Chipping Parish Council

Planning Application Number 3/2012/0718.

Back Lane Chipping.

Chipping Parish Council object to these plans on the following grounds.

Proposed Plan

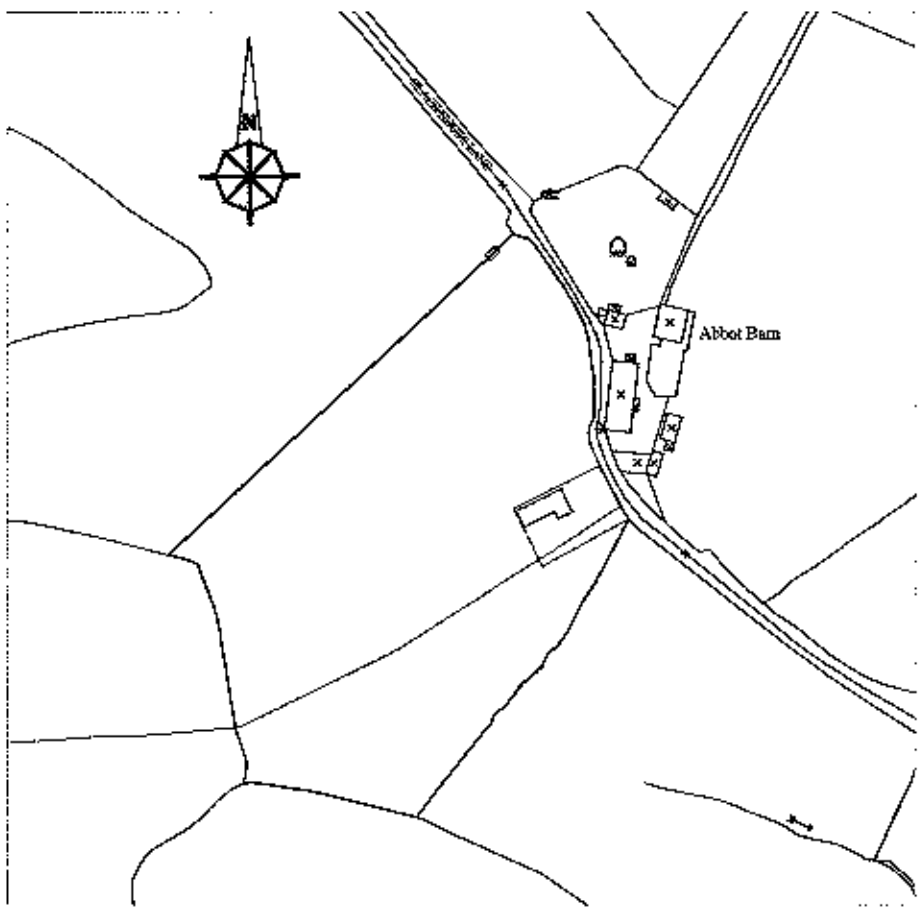
1. The planned stone building should not be built on a green field site.
2. The proposed buildings appear to be excessively large for a reasonable requirement.
